Response to Planning application from Hertfordshire County Council (T and CP GDP Order 2015)

District ref: 6/2023/0241/COND
HCC ref: WH/15711/2023
HCC received: 30 March 2023
Area manager: Matthew Armstrong
Case officer: Matthew Armstrong

Land to the north east of King George V Playing Fields Northaw Road East Cuffley EN6 4RD

Submission of details pursuant to condition number 4 (Construction Environment Management Plan (CEMP), on planning permission S6/2015/1342/PP

Fig. 6.2 Proposed routing between site and M25 Junction 24 (Potters Bar)

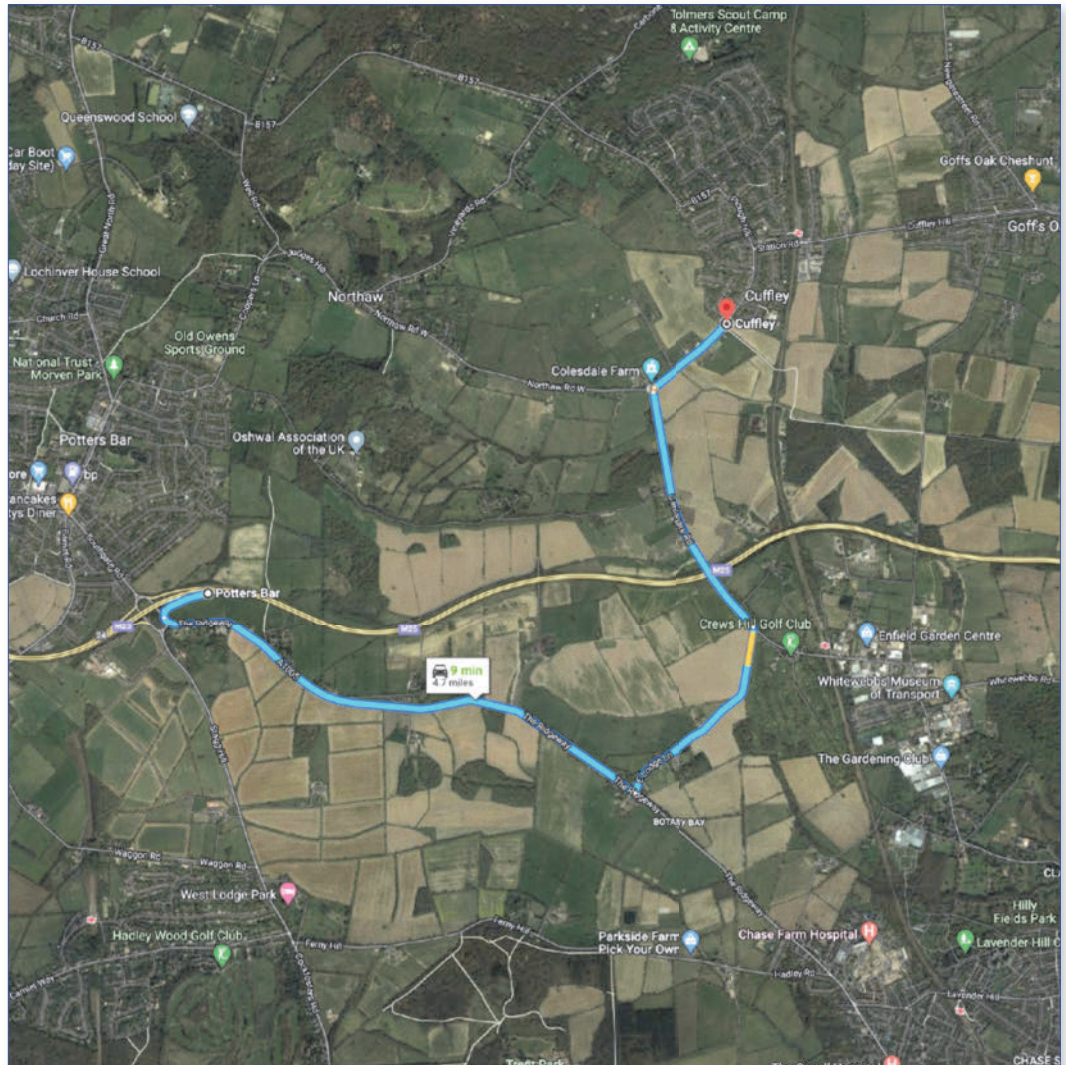
Paragraph 6.1.2 speaks of "all construction traffic (except for very local traffic) will approach the site from M25 Junction 24". We queried the definition of "very local traffic" and this is now defined "as any traffic that would need to travel away from site to reach M25 before returning via the route identified in. We continue to query this: if "very local traffic" is still traffic that needs to reach the M25, then why can it not also use the main route identified?

As mentioned before, much of the proposed construction traffic route is outside of Hertfordshire, within the boundary of the London Borough of Enfield. Therefore, if they have not already, the LPA should consult the London Borough of Enfield on this CTMP for their views too.

Fig. 6.4 Temporary site access image mark up

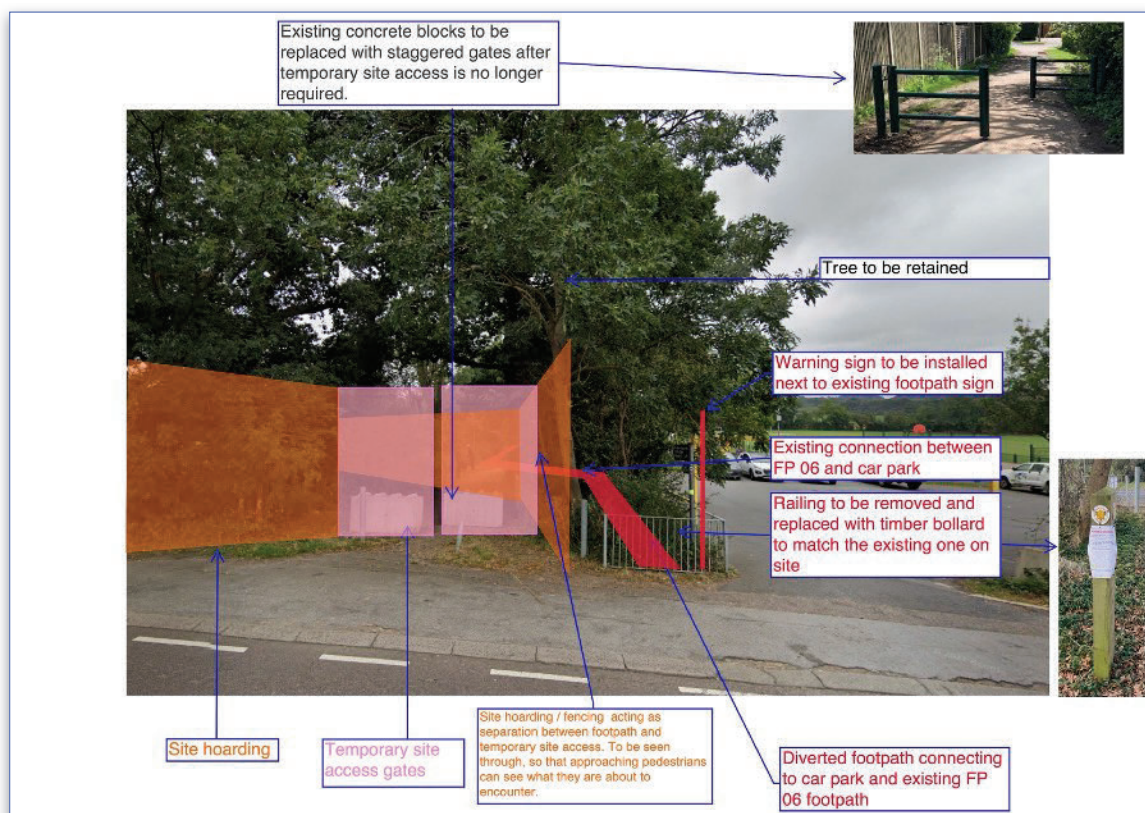
Section 6.3 now states that a minor works licence is being applied for to create a temporary access in advance of the permanent s278 access. The temporary access will be at the same location of the permanent access, and consideration of this (including safety design checks) can be progressed by our Implementation team.

However, this section of the CTMP still proposes to use the 'existing' access in advance of this, which marks the start of public right of way (Northaw Footpath 6). This continues to raise significant concerns, and there is still no detail in the CTMP as to how users of this right of way will be protected from construction vehicle movements, and the design and setup of this access (e.g. levels of visibility, width, tracking plans, what types of vehicles will route through, for how long, surfacing, etc). It is our view that this access point and the right of way are fundamentally unsuitable for any construction traffic due to safety impacts, and we object to the discharge of condition on that basis.
